Your Ref: OWPC25461
Our Ref: LU/341/19/PL 08-11-2019
Please ask for:
Andrew Wood

Combining two adjoining flats & alteration to glazing.
37 & 43 Beach Crescent Littlehampton

Thank you for your internet representation made on 18th January 2020 which has been recorded as '**an objection**' with the comments as follows:

Proposed South Elevation NTS

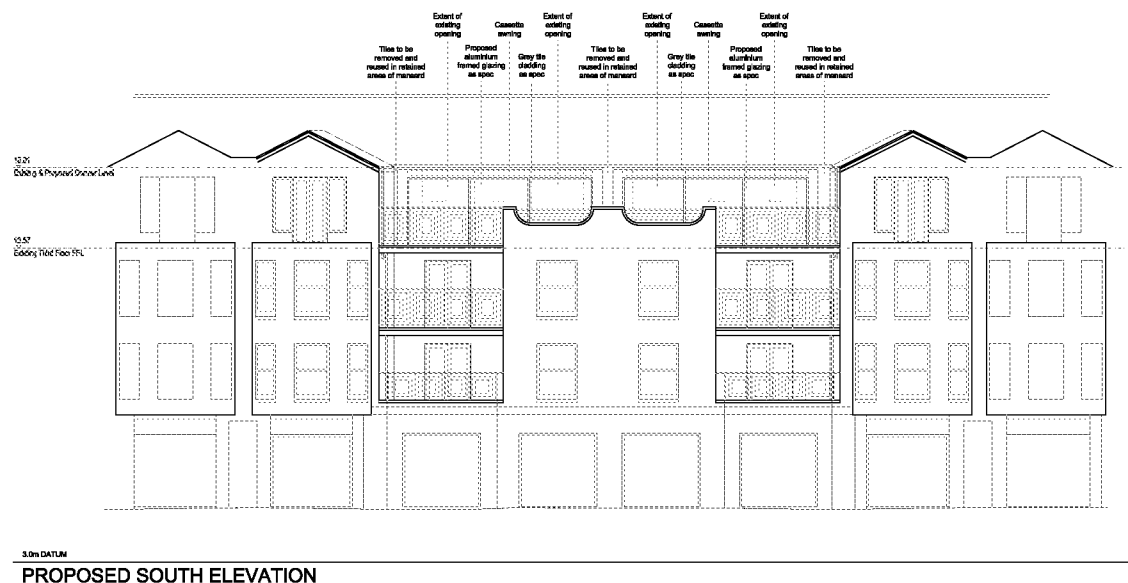
The facade of the building on the South Elevation will materially be altered by the inclusion of new glazing. The plans submitted only show the change to the two flats and do not show the adjacent flats to provide a view of the changed appearance. The landlord has taken steps to maintain the outward aesthetic appearance of the buildings (including requesting the removal of satellite dishes). Previous request to replace external glazing have only been approved on the basis that the look of the building is unchanged. Approval of the glazing changes will only lead to more alterations in the future changing the appearance of the building further.
